CONSULTEE RESPONSE (Council's Arboriculturist)

Reference: R/80/26/HH

Proposal: Removal of existing garage and replacement with a new garage and front porch. Air source heat pump. Removal of existing conservatory and replacement with a new single storey rear extension. New garden room with pool and associated spaces.

Location: Willow Green, 41 Angmering Lane, East Preston, BN16 2TA

Drawing Title: Tree Protection Plan	1:250@A3
Appendix: A	May 2026

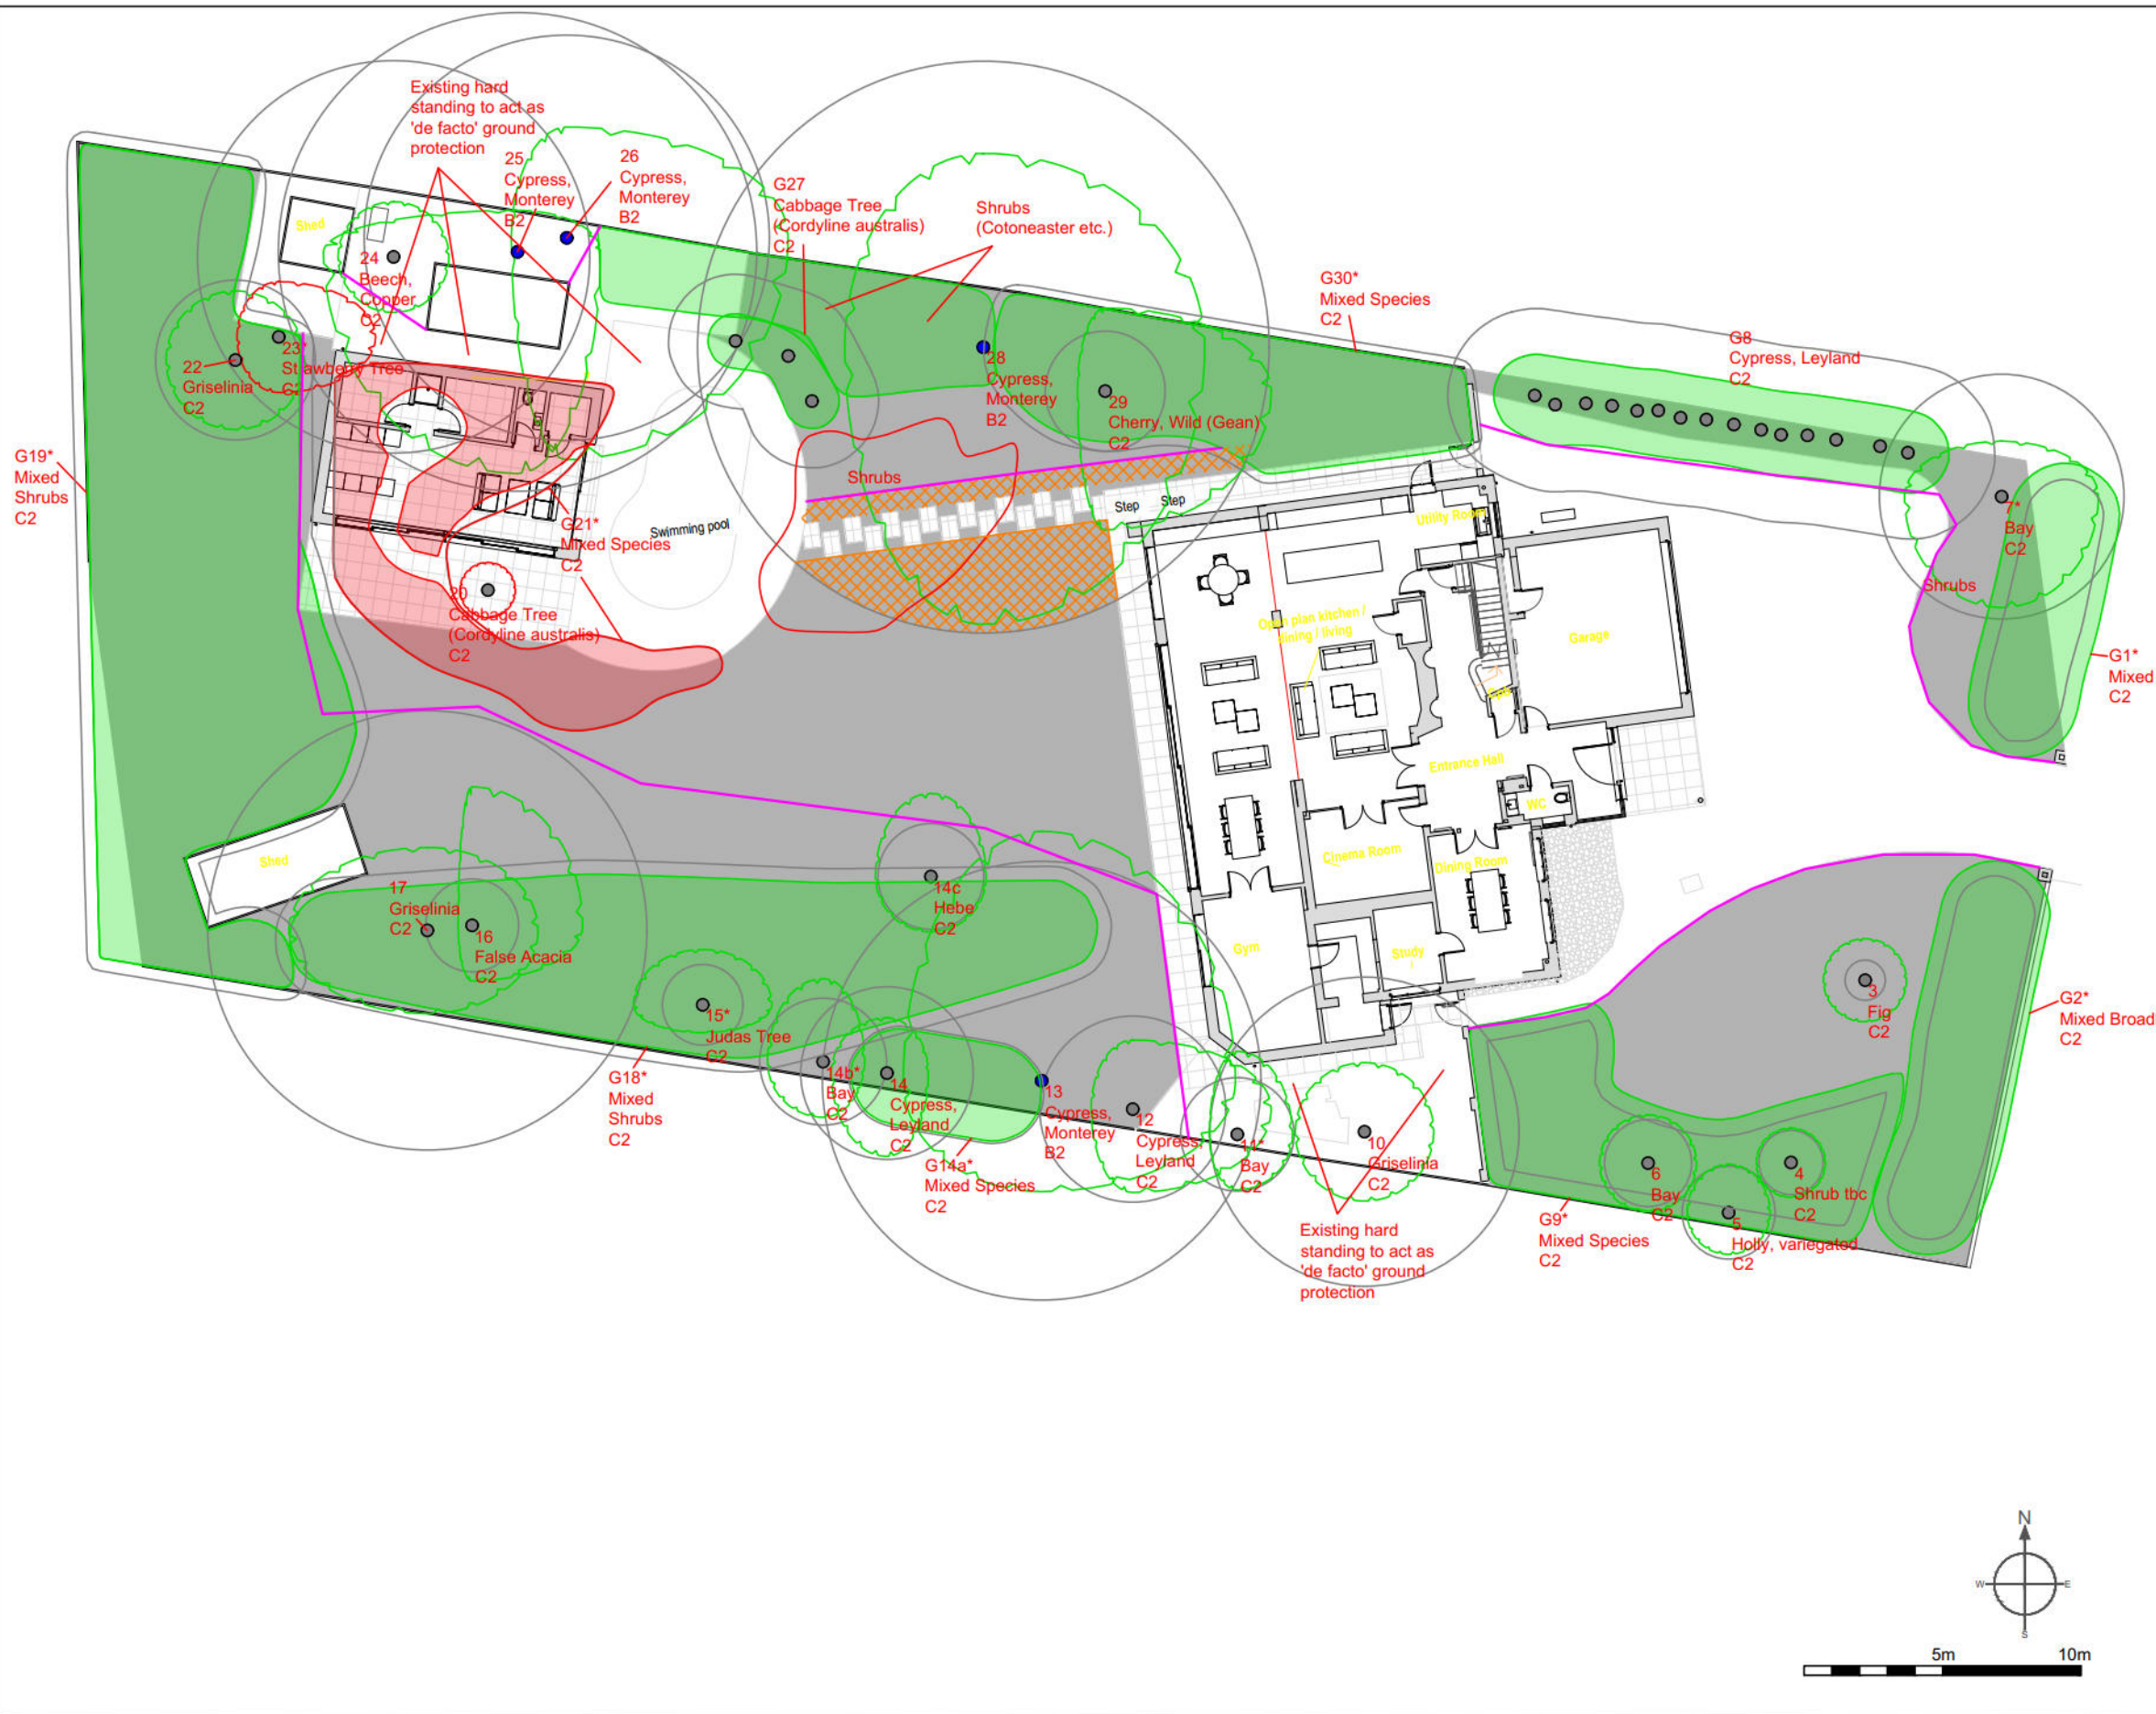
The extent of root protection area (RPA) incursion affecting trees on the northern boundary, from extension of the building footprint and introduction of new, are within recognised tolerance level or mitigated by special engineering measure (e.g. screw pile foundation). Risk of harm from above ground activity is mitigated by the use of temporary ground protection and robust fencing.

No development/demolition/levels changes (apart from any survey works required by other conditions) shall take place and no heavy plant shall be introduced to the site, unless and until written confirmation (supported by photographic evidence) is provided by the Arboricultural Expert representing the site owner(s), that all protective fencing and ground protection has been erected and positioned exactly as described and illustrated in

Appendix: A - Tree Protection Plan, Arbortrack Systems Ltd. May 2026
